Our Case Number: ABP-316119-23

Re: DART+ South West Electrified Heavy Railway Order - Hazelhatch & Celbridge Station to Heuston Station, and Hesuton Station to Glasnevin
County Dublin and County Kildare

Observations for the DART+ South West Railway Order Application

Le Fanu Road Bridge OBC7 Ch12+660

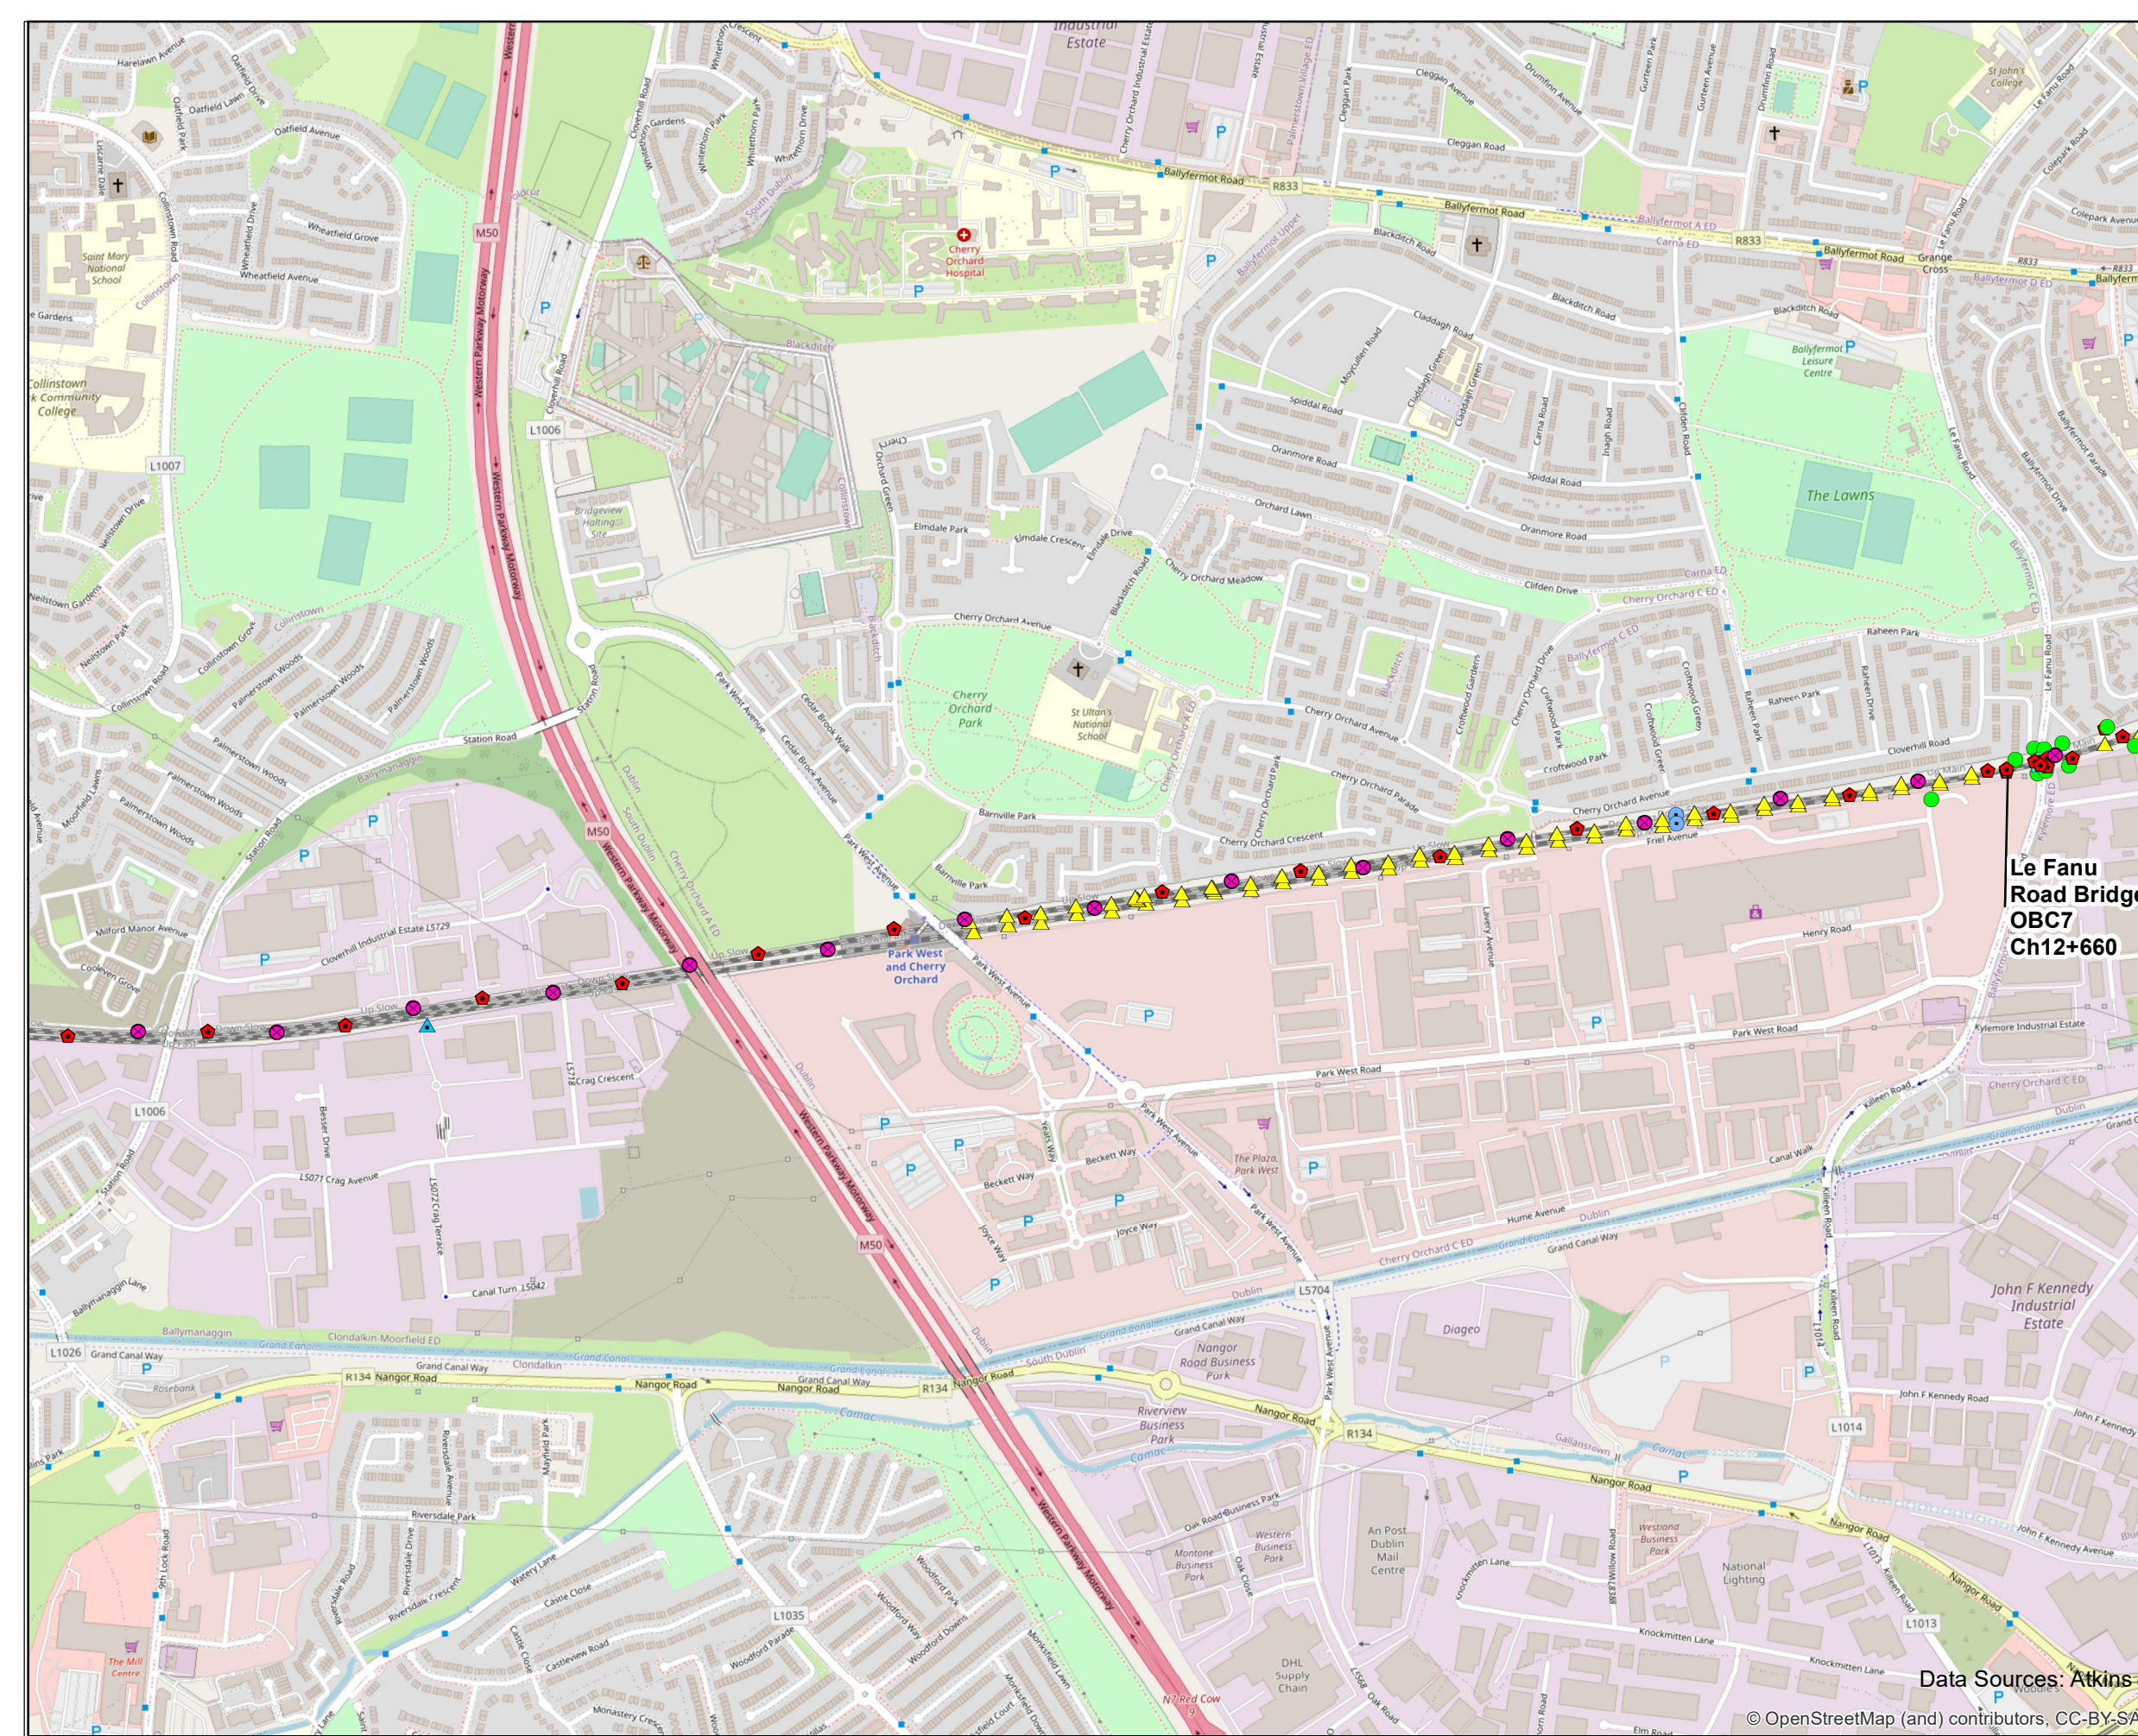
After reading through and assessing the EIA, I have found that two of the three bridges (Kylemore bridge and Le Fanu bridge in Ballyfermot) that are proposed to be demolished in this project have not been fully assessed/surveyed for bat roosts.

In the EIA, it says that RPS were not able to gain access to these bridges because of health and safety issues. I do not think this is a reasonable excuse for not surveying these bridges. Iarnrod Eireann need to be able to access these bridges and could have accompanied the ecologists during their surveying.

There is public land directly adjacent to the Le Fanu bridge where entry and re-emergent surveys could have been conducted. This is a proposed construction compound (chainage 12+590)

The mitigation proposals (installation of 2 Schwegler 1FF and 2 Schwegler 2F bat boxes for Le Fanu bridge) are not enough for bridges that have not had complete bat surveys done. The proper investigations should have been undertaken before the project has reached this stage of seeking planning permission.

I would like an EIA survey carried out by a different and/or independent organisation on these bridges for the presence or absence of bat roosts. I know there are Soprano Pipistrelles roosting in the Le Fanu bridge and would like this confirmed or not before this project is given the go-ahead by An Bord Pleanála.
